ADDRESS . . : 131 KIMBROUGH DR
 CONTRACTOR : CAVINESS LAND DEVELOPMENT
 OWNER . . . : CAVINESS LAND DEVELOPMENT
 PARCEL . . . : 01-0536-06- -0028- -15-
 APPL NUMBER: 09-50022370 CP NEW RESIDENTIAL (SFD)
 DIRECTIONS : WOODSHIRE #175
 TAKE 27W APPROX 8MI. T/L ON NURSERY
 ROAD, GO APPROX 3MI. T/L ON WOOD POINT,
 GO APPROX 0.3MI, T/R ON KIMBROUGH.
 T/S: 06/29/2009 11:17 AM RDCONTE ---

VIOLATION NOTICE

Job Name: Caviness Land Date: 9/15/09

Address: 131 Kimbrough Dr.

Job J92881	Truss FT2	Truss Type FLOOR	Qty 1	Ply 1	Cav. Land / Lot 175 Woodshire Job Reference (optional)	E6450454
---------------	--------------	---------------------	----------	----------	---	----------

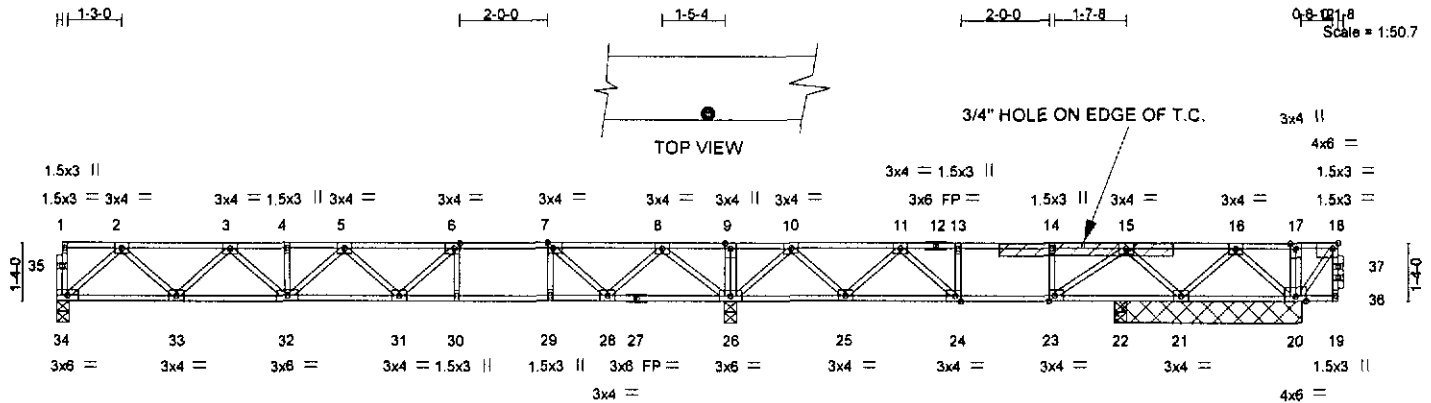
Violations Found: 1) Triple I joist must have 6 inch bearing both sides. (All the way to slab)
2) Need engineer repair for truss bored for master toilet water line & damaged floor truss web above laundry room to left of door.
3) Fire block top plate of front dining room wall.
4) Draft stop master shower drain
5) Need nail guard for #12 wire in master bath.
